From: Tim Rainbird [REDACTED]
Sent: 01 August 2017 12:12
To: Paul Cann; Simon Davis
Cc: Tom Woolner
Subject: RE: BE/71/17/PL - Wickes, Bognor Drainage Scheme

Whilst I acknowledge the difficulties due to Network Rail's requirements, and the fact that the pumping station option may be commercially sustainable in this instance; it is not however environmentally sustainable in the long term. It's a shame the original gravity option to the Sainsbury's system was not implemented, and was clearly an oversight.

Having said that, we appreciate the predicament, and will in this case accept the principle of the pumping option. In order to progress matters in terms of formal approval, please could the following be provided;

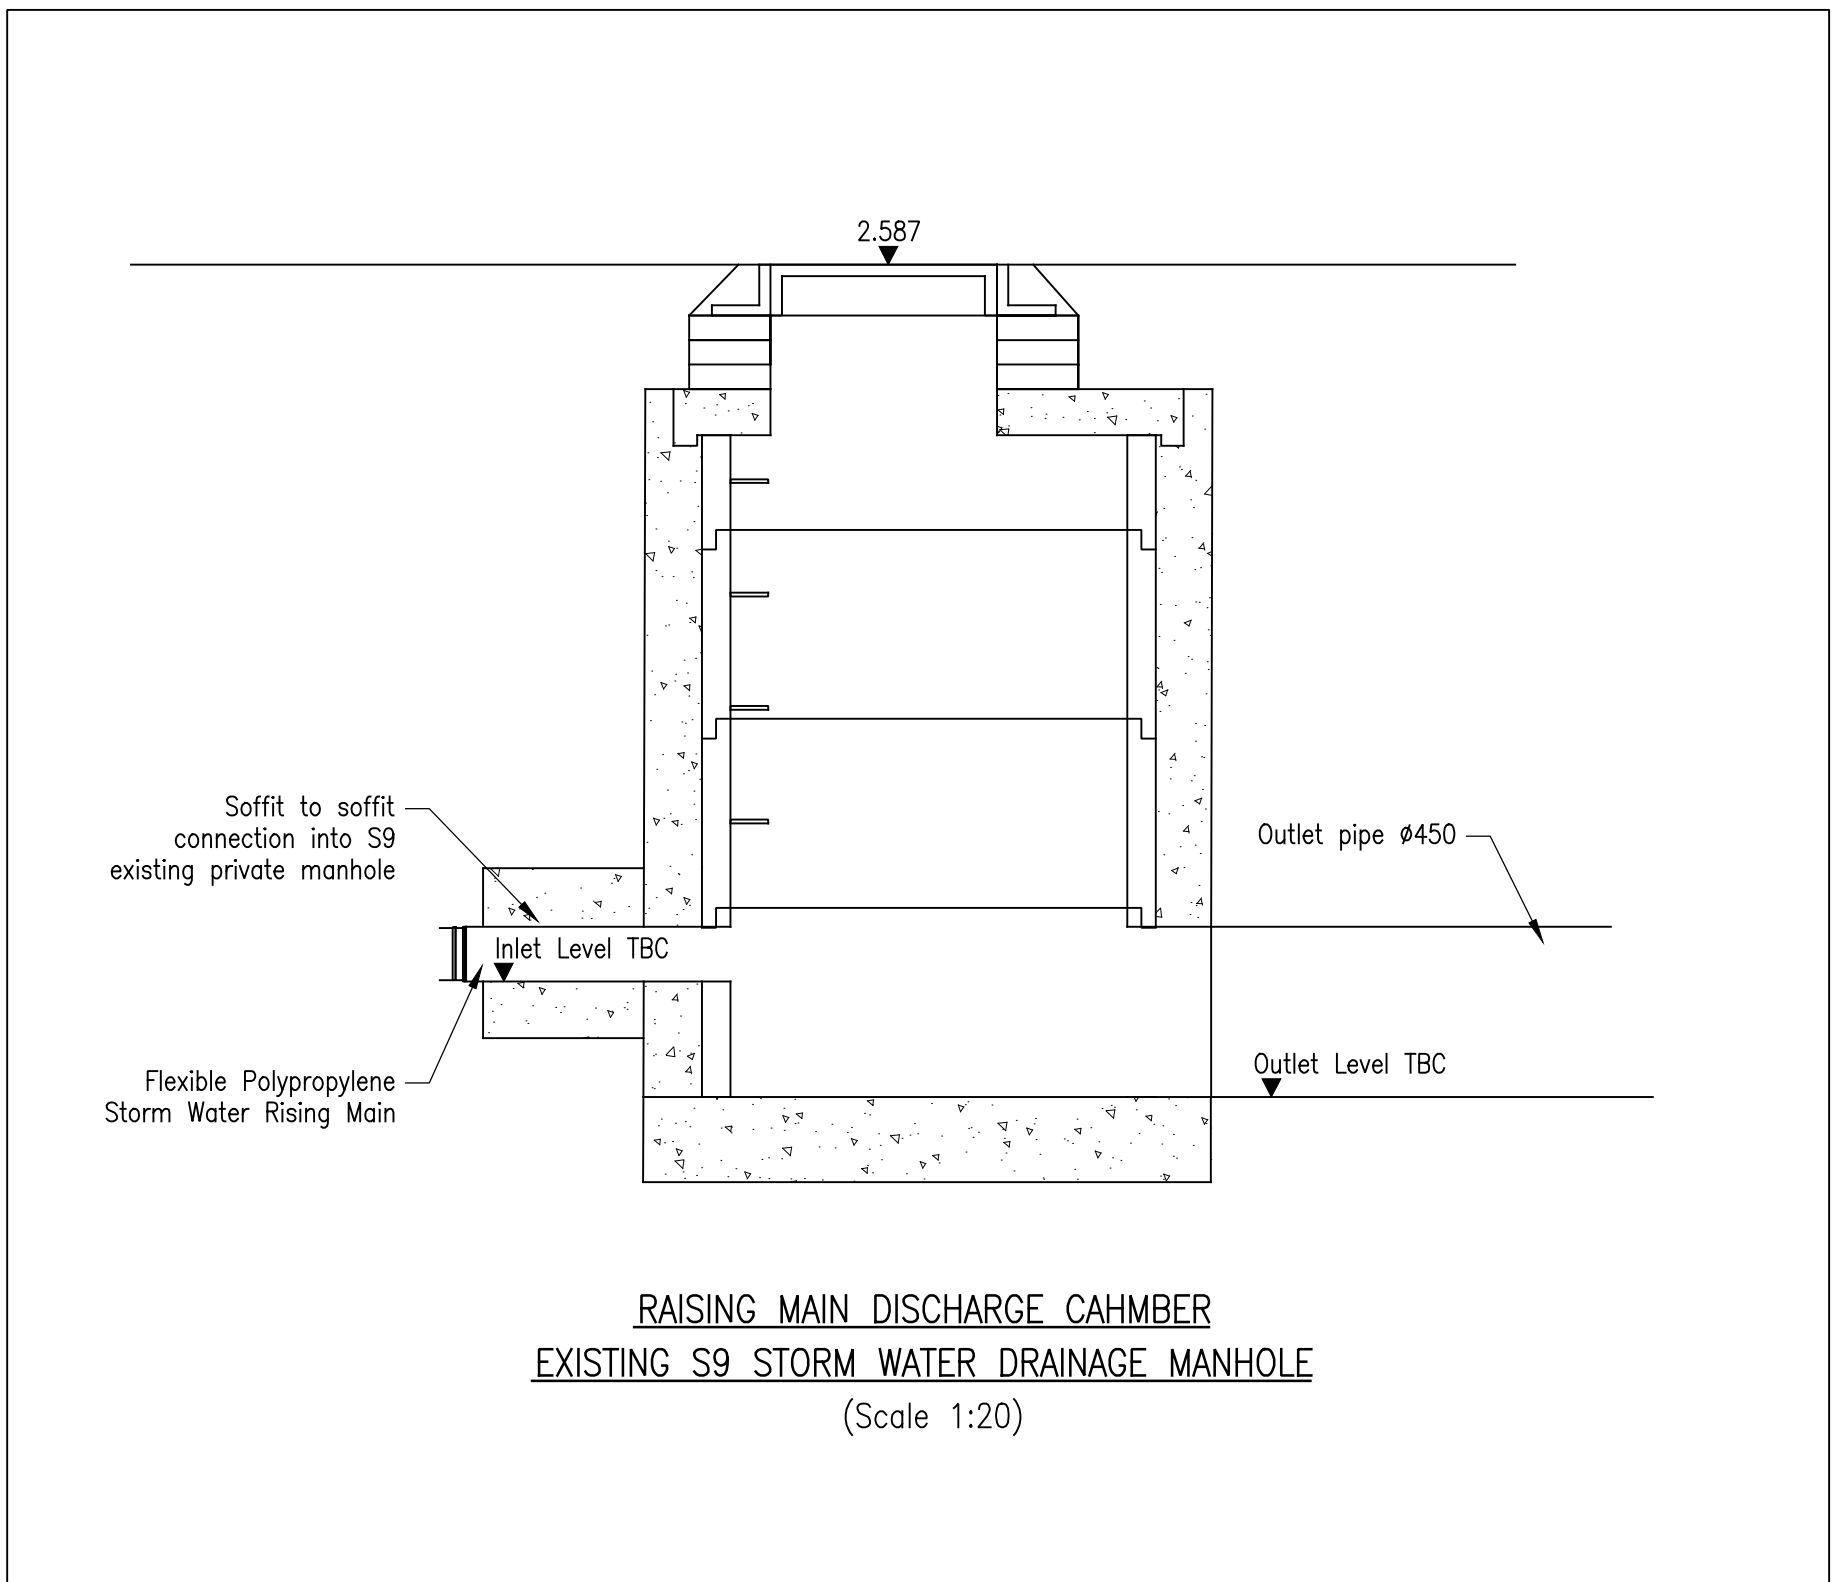
1. Full construction details of the pumping station and rising main. This will also need to include pipe bedding details, thrust block details and discharge chamber details.
2. Malfunction alarm details for the pumping station.
3. Pump manufacturers design/spec.
4. A maintenance plan for the future operation/maintenance of the pumping station.

It is important that the pipework configuration is considered carefully within the discharge chamber to ensure the smooth transition of flows. This will need to be detailed.

Typical details are on the attached drawing 15-112/500

The current discharge point is labelled as manhole S9 on the attached 'as built' drawing from the adjacent Sainsburys development. Specific details of this chamber is unknown although those of upstream chambers S10.1 and S10 are. Hence levels will be confirmed to the pump supplier when the contractor orders the pump.
